Our Ref: 20/01261/ADV
Your Ref: 121 Highland Road
Shopfront

LOCATION: Shop, 121 Highland Road, Southsea, PO4 9EY

PROPOSAL: Display of 2 no. non-illuminated fascia signs and 1. non-illuminated projecting sign to shopfront **(20/01261/ADV)**

Title
Existing and Proposed
Shopfront

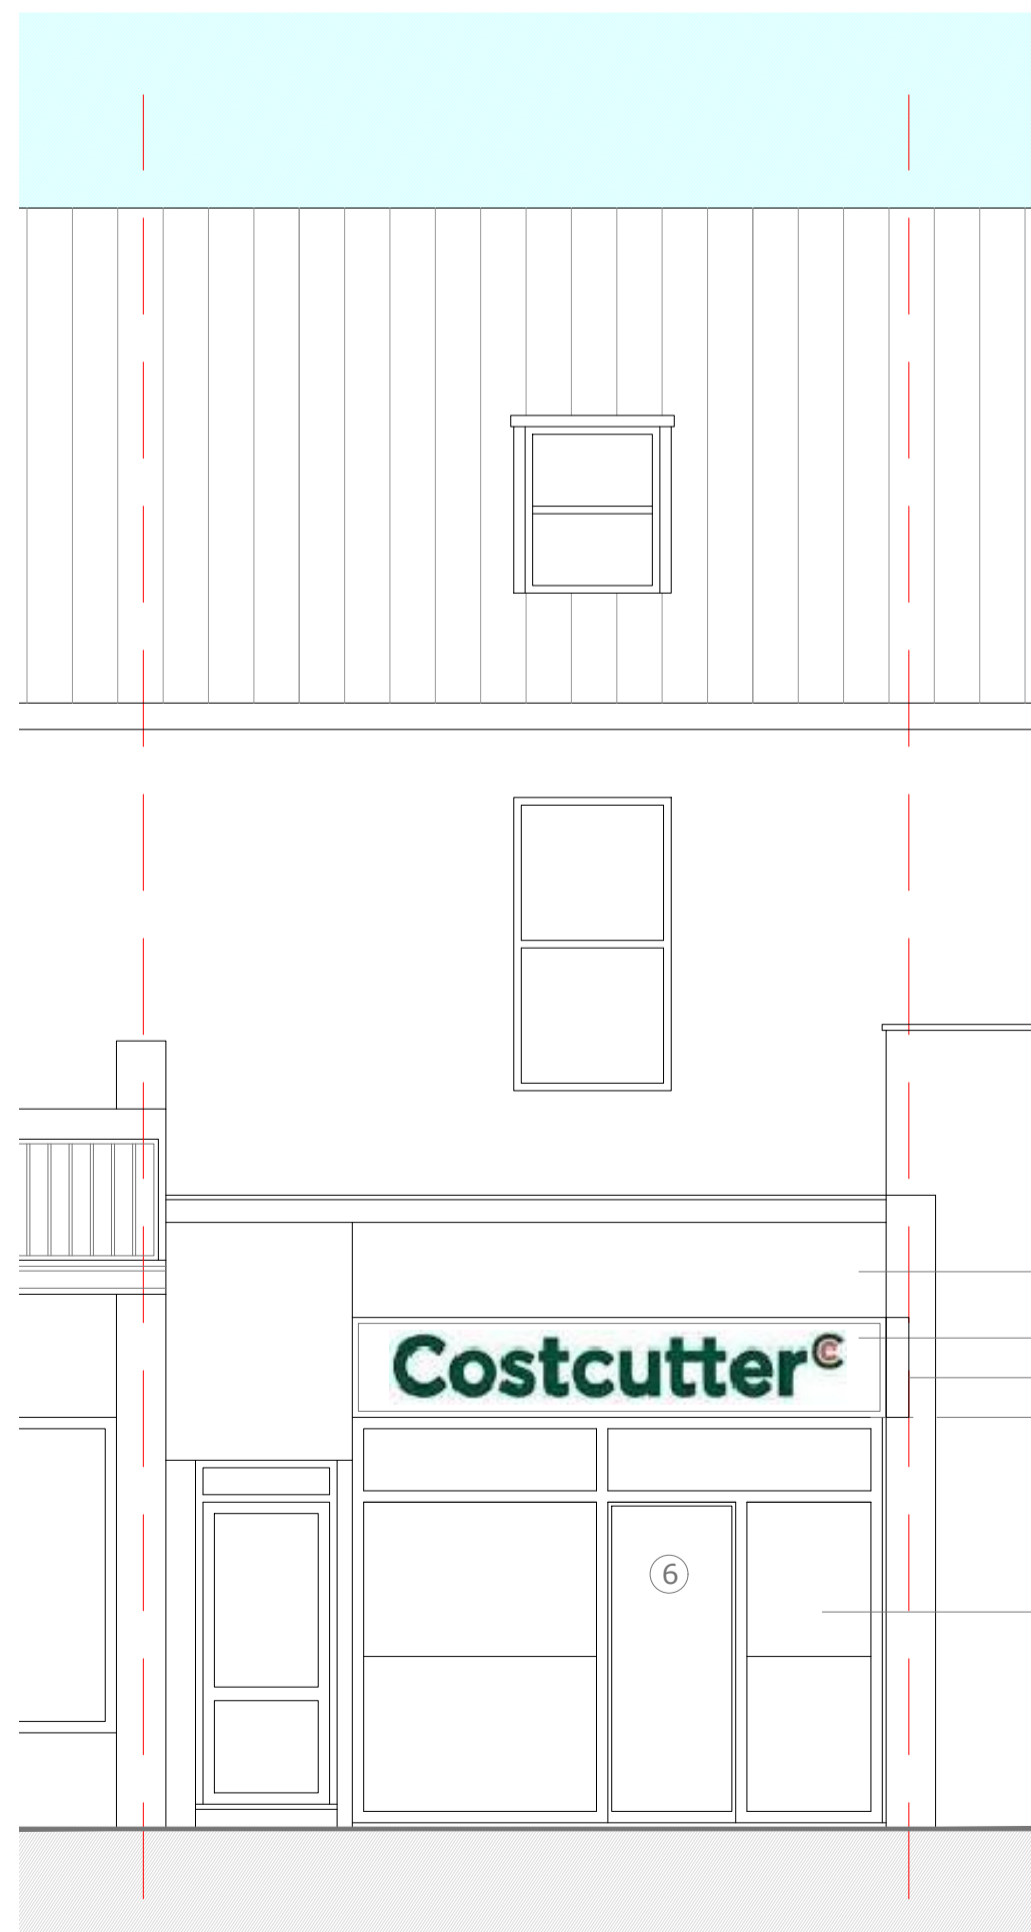
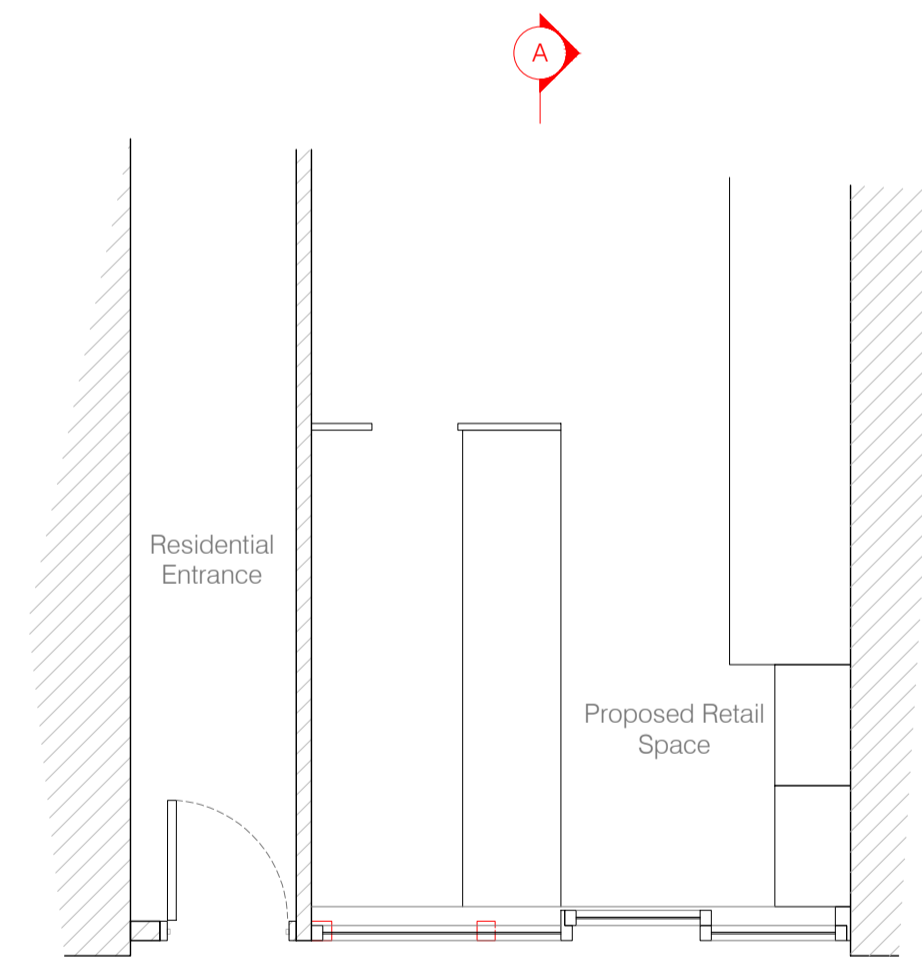
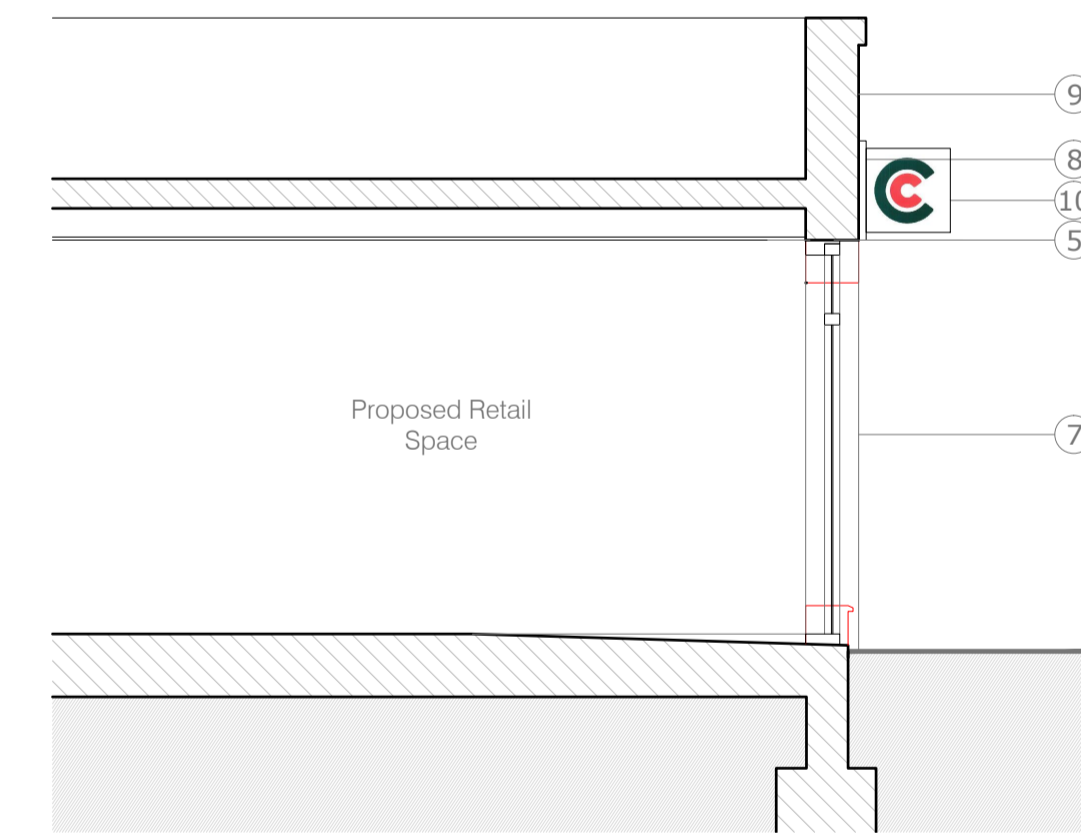
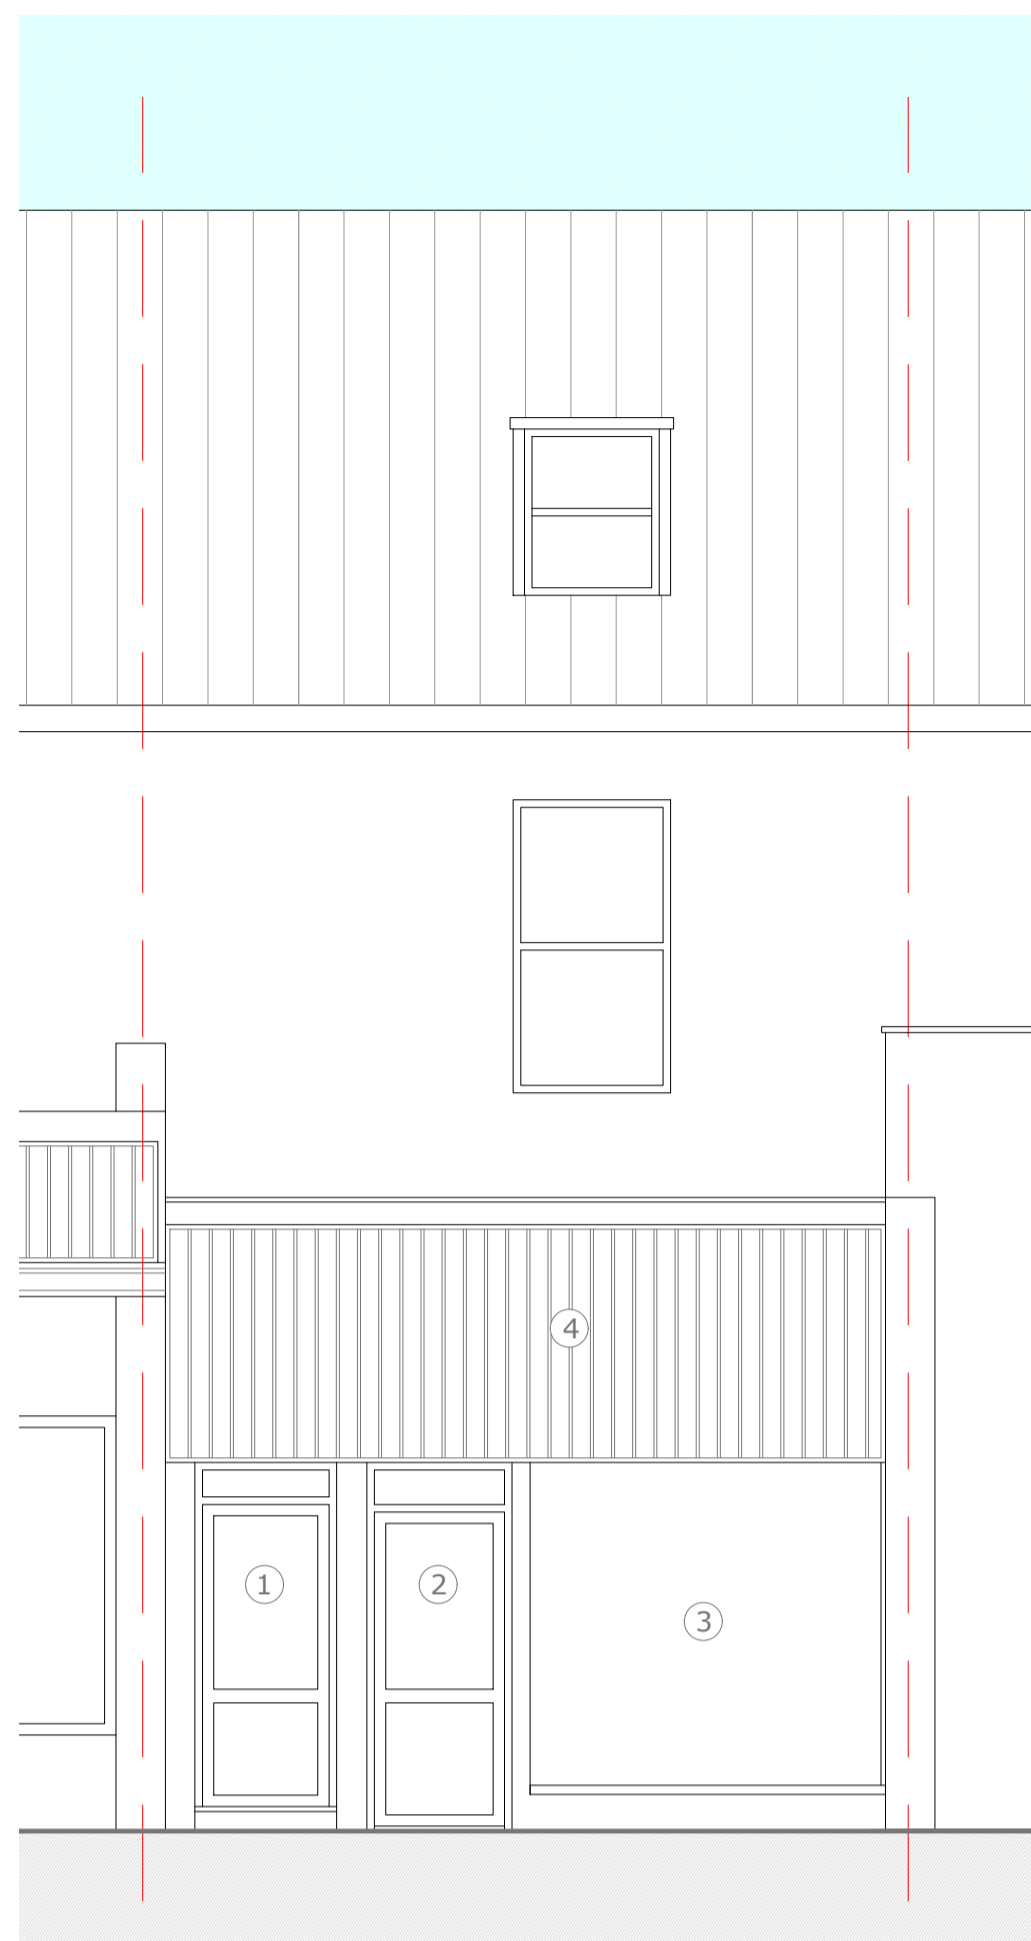
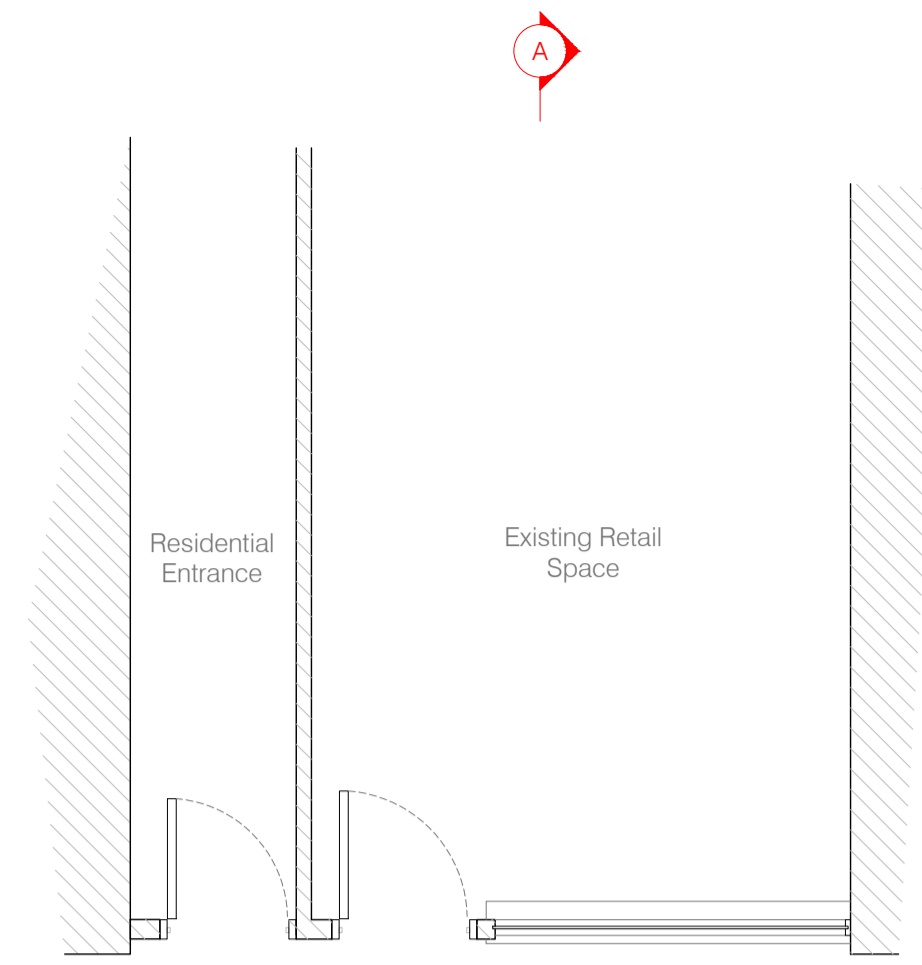
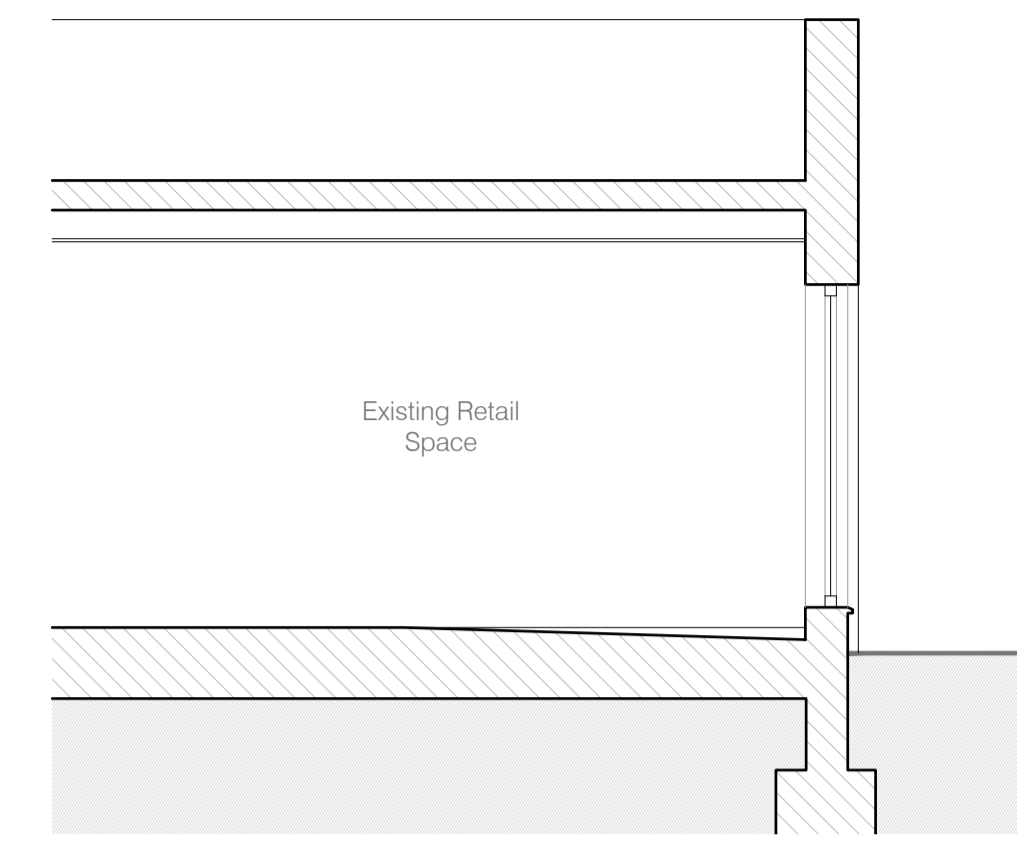
1) Please submit further plans with more details for the fascia and projecting signs. I am unable to complete measurements of the signs to match those given on the application form for height, width, depth, height of letters, ground to base, max projection etc.

2) The submitted plans are not to scale, please submit 3 copies of plans to a metric scale of 1:50 or 1:100. The drawing states 1:50 but 3m measures at 6m.
